Consultation Response from: KC Environmental Health (Pollution & Noise Control)

2025/90261 York House 198 Barnsley Road, Denby Dale, Huddersfield, HD8 8TS

Reserved matters application pursuant to outline permission 2022/91024 for demolition of existing works and erection of residential development (3 detached dwellings)

Responding Date:
5th August 2025

Figure 5 – Site Location with background monitoring location

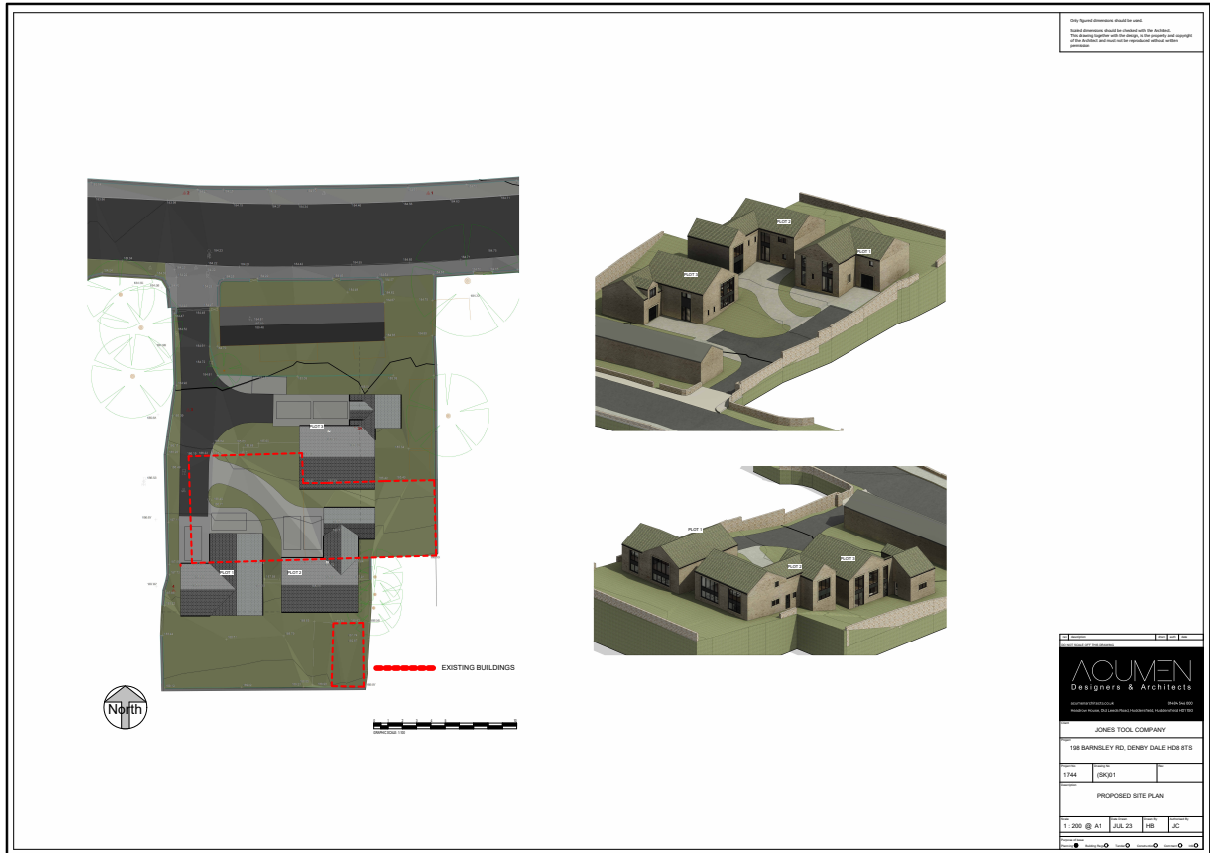
A noise survey was undertaken on Sunday the 18th of February 2024 at a position that had direct line of site to the A road identified. The day was chosen due to the continued operation of the works on site which would not exist once the development begins. Monitoring position as shown in figure 5 and a summary of the findings is given in Section 6.
